OBSERVATION/SUBMISSION TO PLANNING APPLICATION

Case Reference: 324113

Re: Observation to the proposed development of open-cycle gas turbine (OCGT) and generator with ancillary equipment.

Location: Pollnagroagh and Rathmorrissy (Townlands), Athenry, Co. Galway

Purpose		PLANNING			
Title		SITE ACCESS SIGHTLINES			
Original Scale	Design/Drawn	Checked	Authorised		
SHOWN at A1	PS	ND	AJB		
Date	Date	Date	Date		
01.12.25	01.12.25	01.12.25	01.12.25		
Status	Drawing Number	Rev			
A2	PEK3-ATK-ZZ-01-DR-CE-901200	0

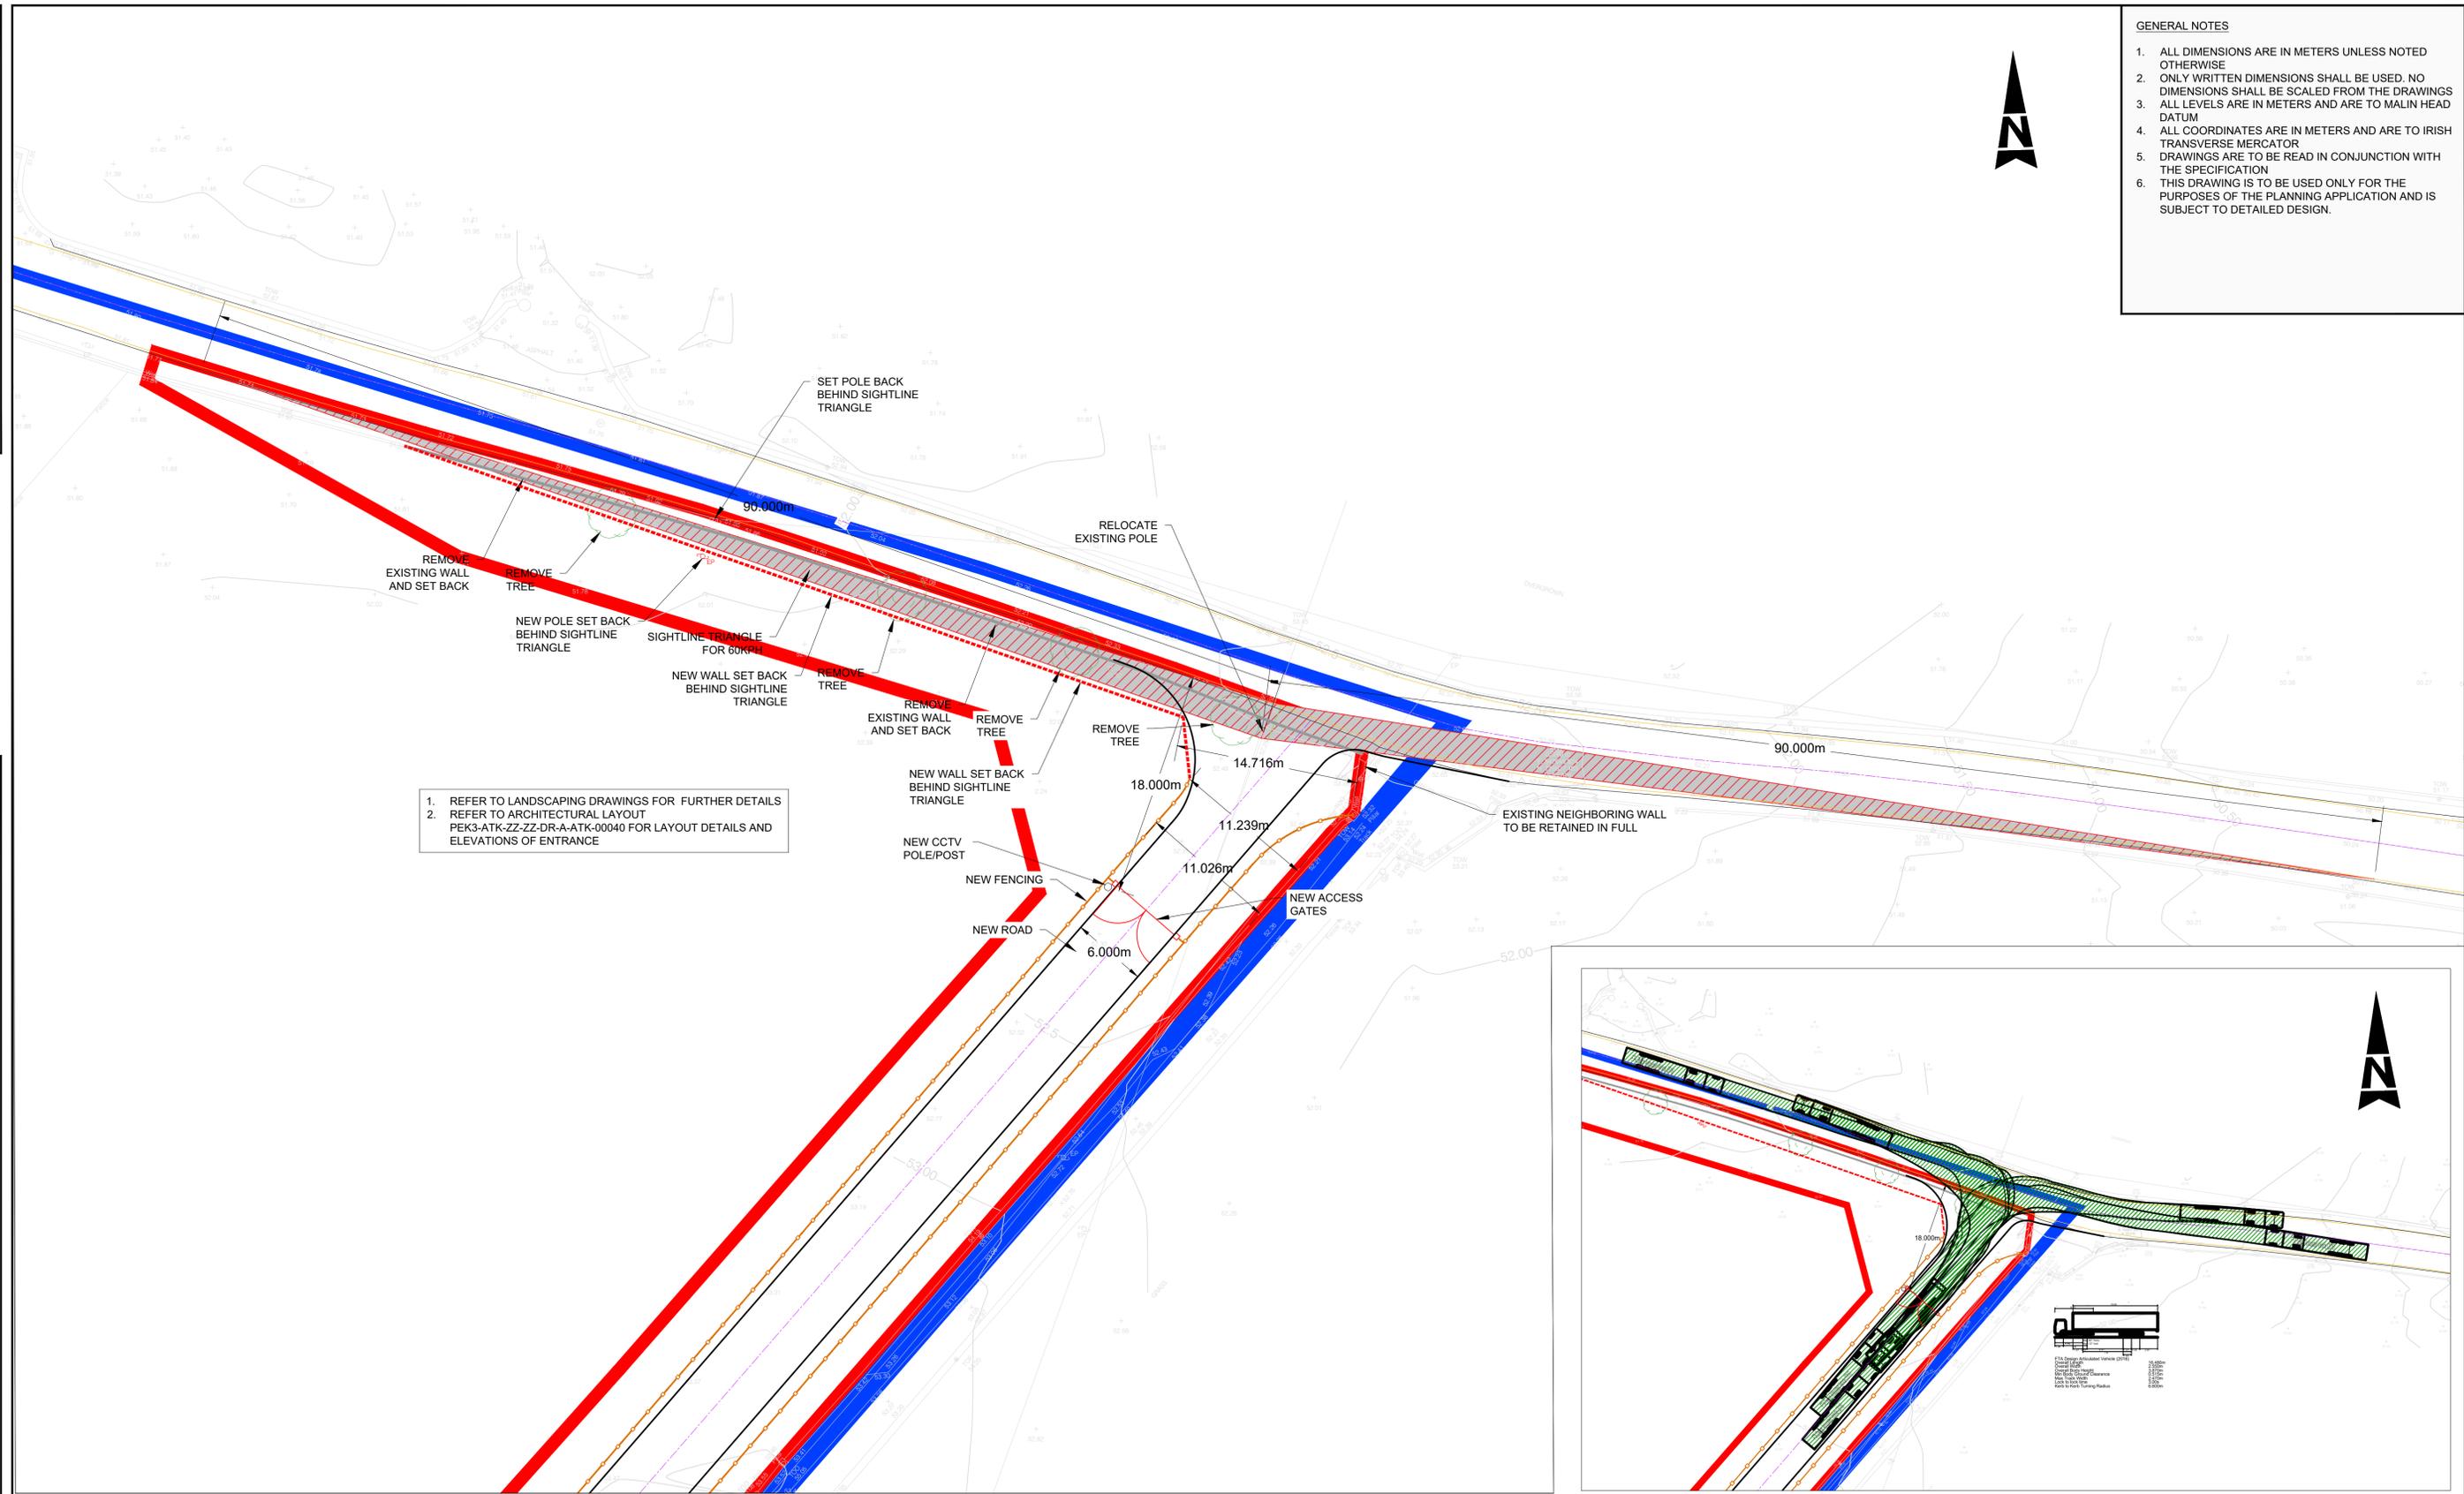
There are serious concerns about the proposed site entrance on the L3103, which is an exceptionally dangerous stretch of road where introducing an access point would create an unacceptable level of risk. The road is extremely narrow and cannot safely accommodate two heavy goods vehicles passing at the same time, there is no hard shoulder to allow for safe manoeuvring or recovery, and visibility is severely limited due to blind dips and sharp corners. These are significant existing hazards that already pose a real danger to road users, and the addition of a site entrance would further increase that risk.

There are also concerns regarding the suitability of local roads for this type of traffic. Rural roads are not built to support continuous industrial activity, and when heavy trucks, farm equipment, and regular local vehicles share these routes, it often leads to difficult and dangerous traffic conditions. The introduction of additional industrial traffic, including construction vehicles and diesel deliveries, would further increase the risk and make these roads more dangerous for all users.
